Comments by F.J.R.Brown IP No. 20044329  
For submission by Deadline 3  
of the EN010117 Rampion Wind Farm Examination

This is a response to the Applicant's Deadline 2 Document 8.53 Category 8 Applicant's Response to Non-Prescribed Consultees' Written Representations- Appendix C

## **Comments on some of the Photo Montages and figures in Chapter 15**

Figure 15.43f
 Viewpoint 18: Cissbury Ring

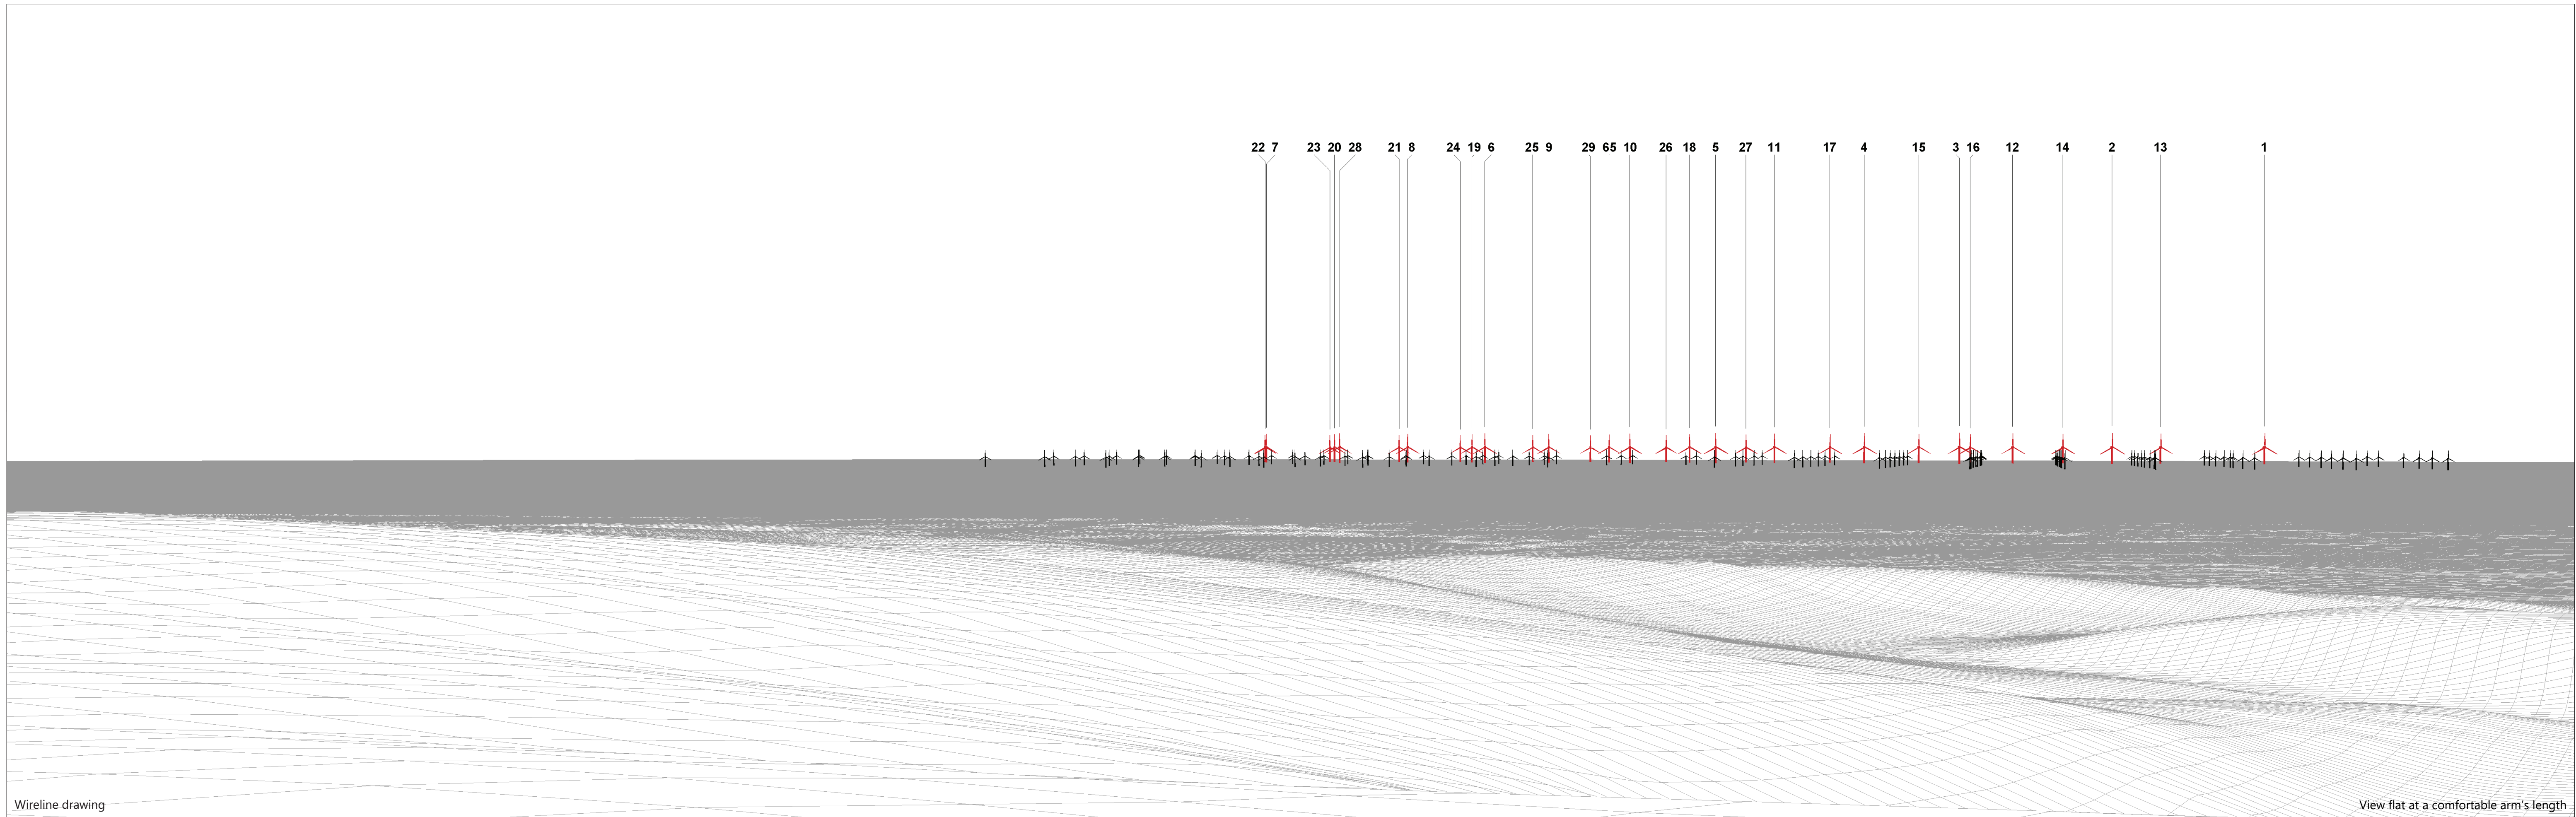
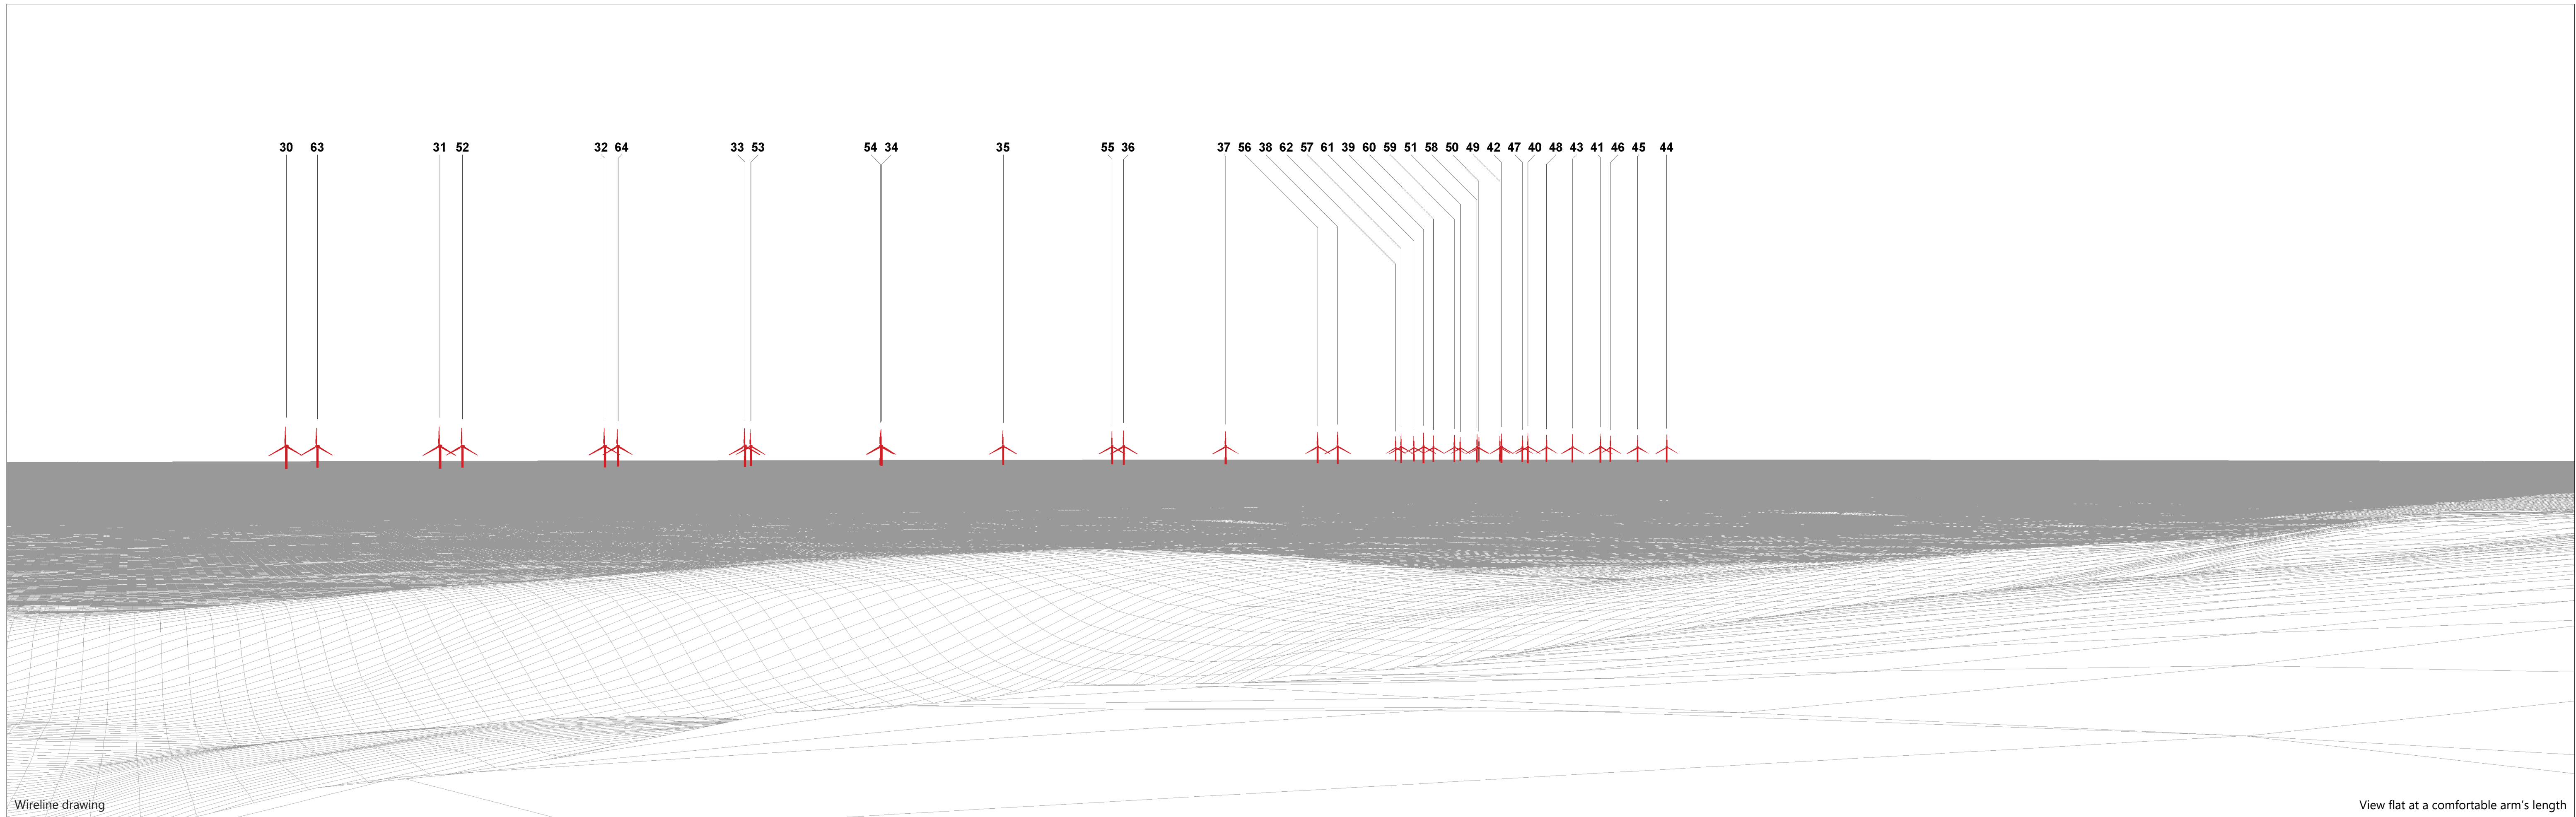
### **Figure 15.43a-h Viewpoint 18 Cissbury Ring**

The view from Cissbury shows that the highly developed urban and suburban spread along the coastal plain is low in terms of scale, and makes few inroads into the seascape as viewed from higher points such as this. Woodland conceals many of the houses, like the nearby ones at High Salvington, that were built specifically to take advantage of the wide outlook over the sea.

In many ways, apart from the strip of roofs beside the coast (and the far less intrusive Rampion 1 wind farm) it's the same seascape the Neolithic Flint Miners looked out on.

Figure 15.44g
Viewpoint 19: Highdown Hill

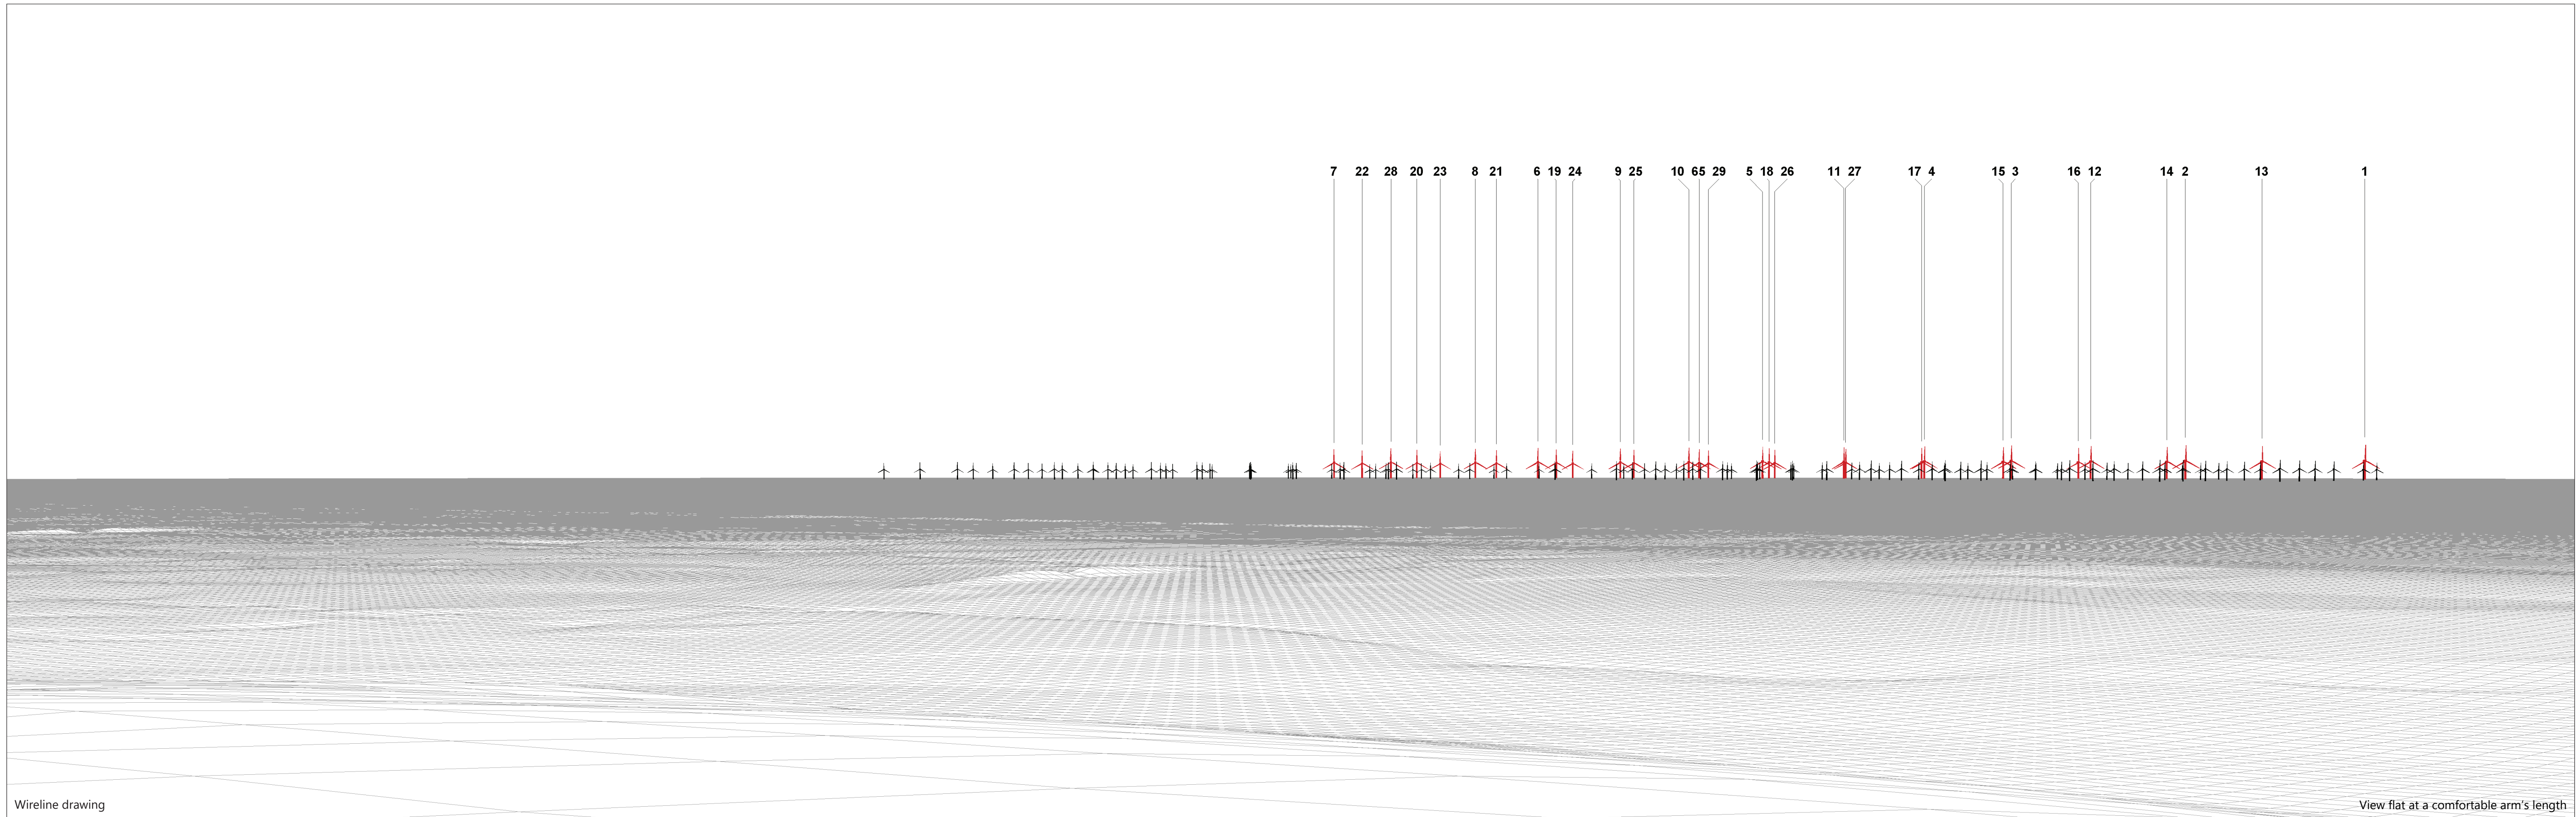
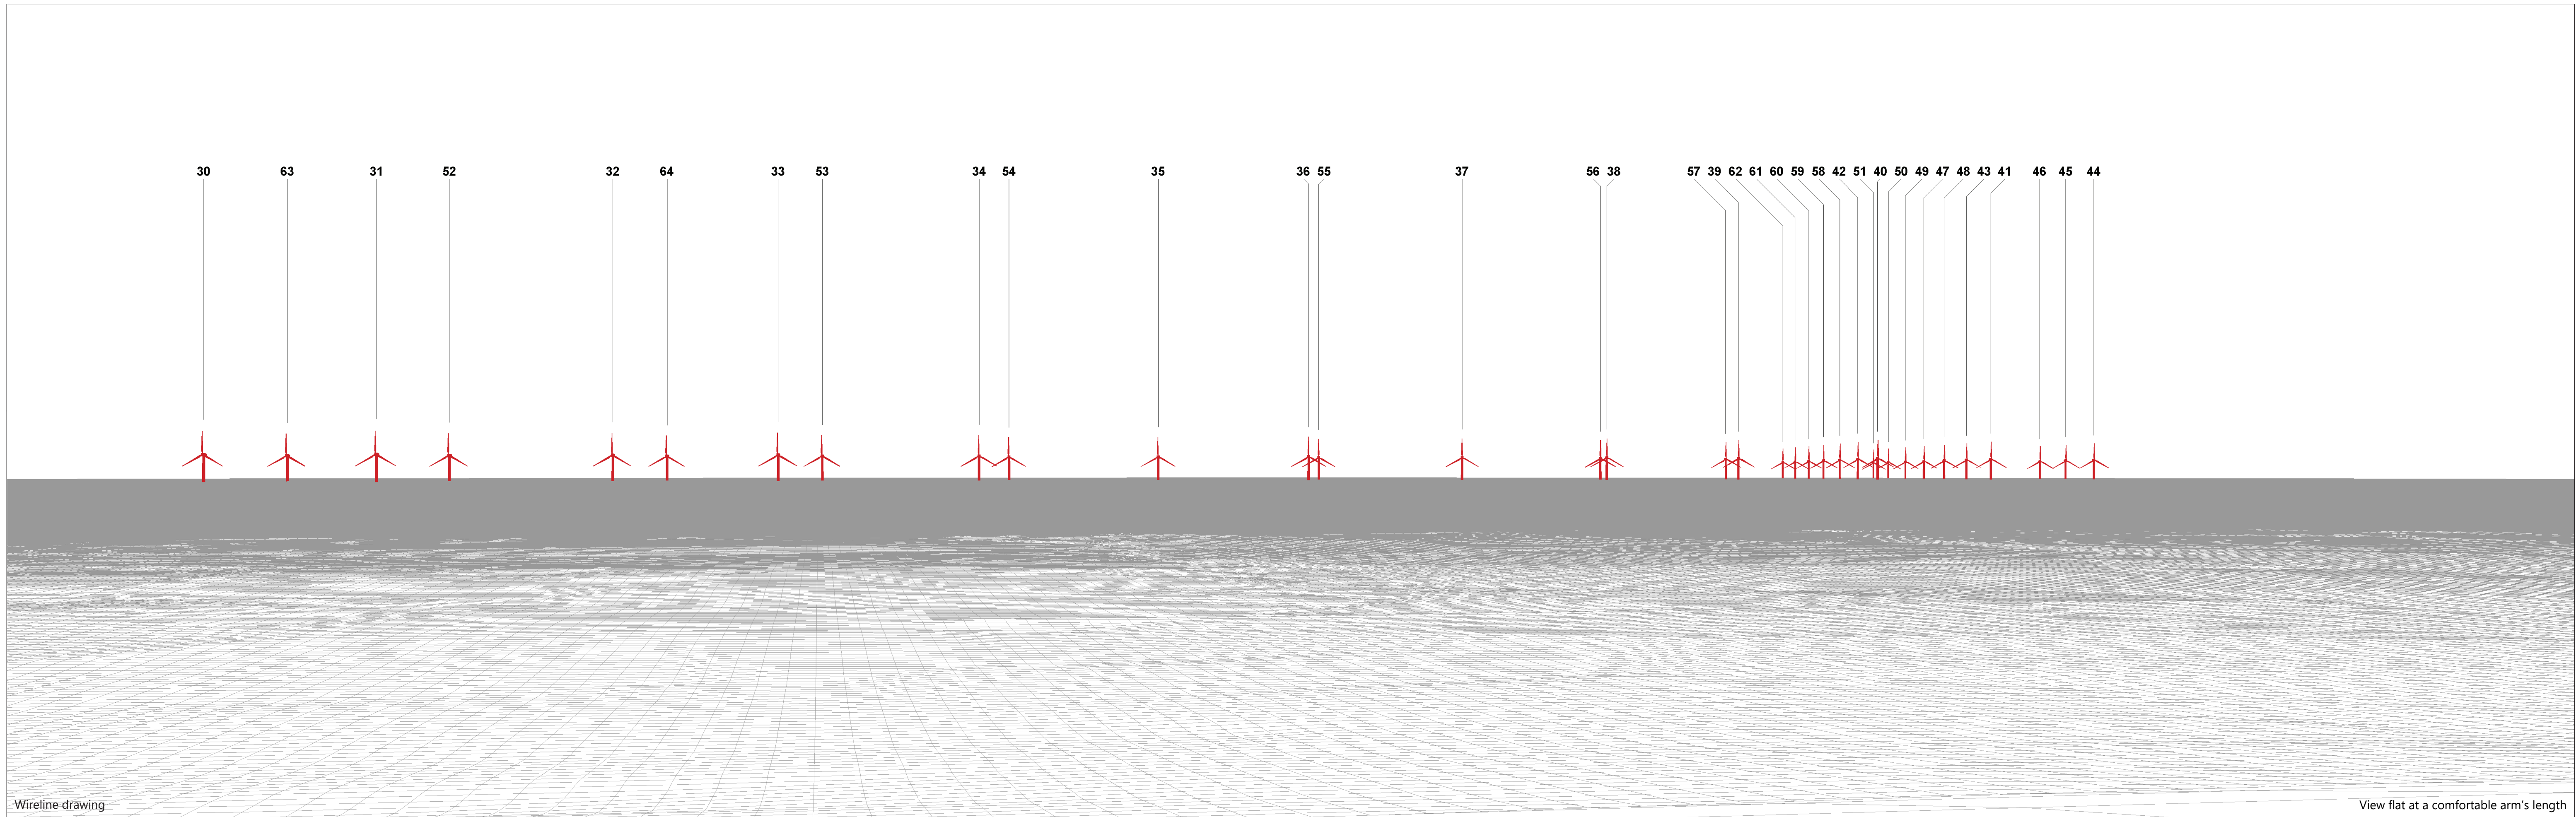
### **Figure 15.44a-I Viewpoint 19 Highdown Hill**

Compared with Cissbury, the Coastal Plain is closer and much more visible here, but nevertheless the bulk of the seashore appears edged and defined by the trees and woods that Kipling and Belloc highlight as the essence of the County – foreground Factories and Glasshouses notwithstanding.

Figure 15.46d
Viewpoint 21: Bignor Hill

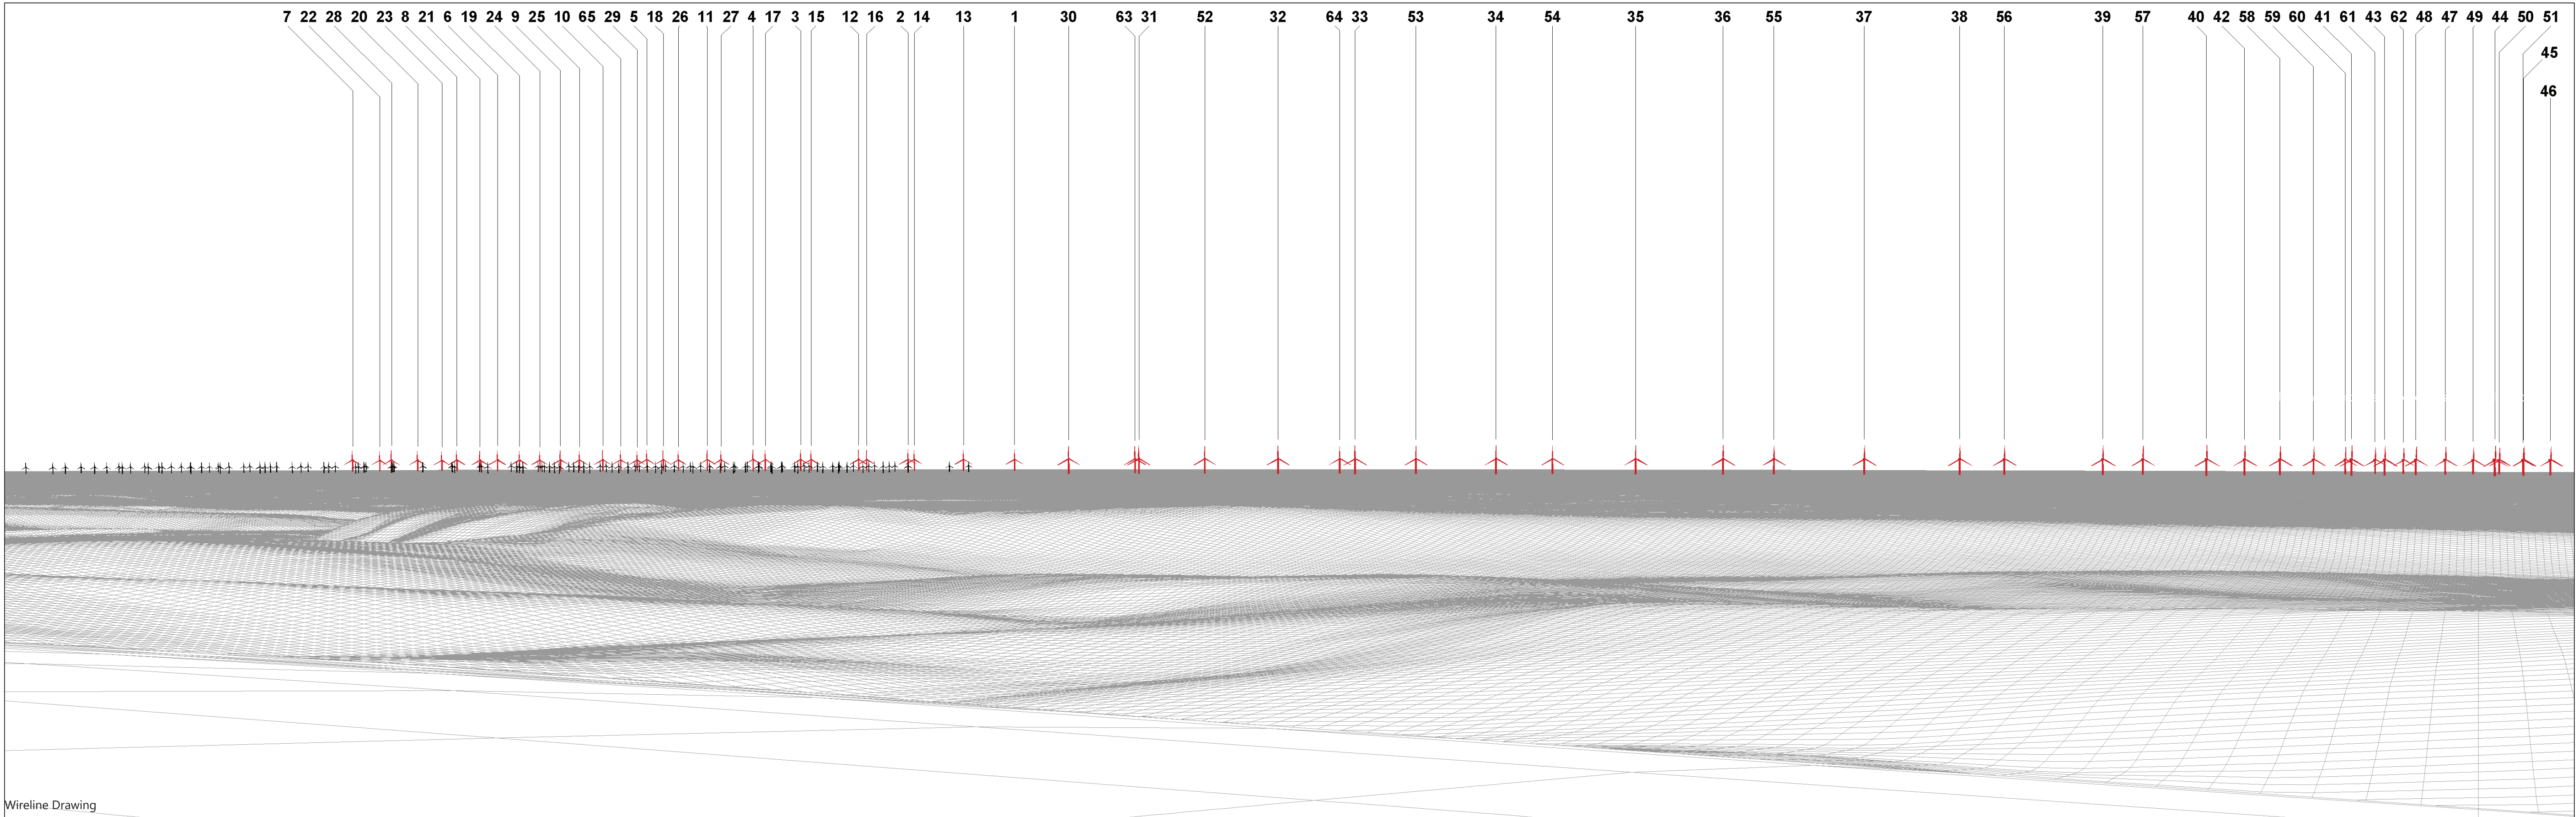
### **Figure 15.46a-h Viewpoint 21 Bignor Hill**

This is the view the Romans saw on their final approach to Chichester on Stane Street.

Despite being located above the sprawl of Bognor Regis, the coastal conurbation is barely visible. But the large turbines would have a disproportional impact on this mostly rural outlook especially at night.

Being higher, this view point reveals a larger seascape.
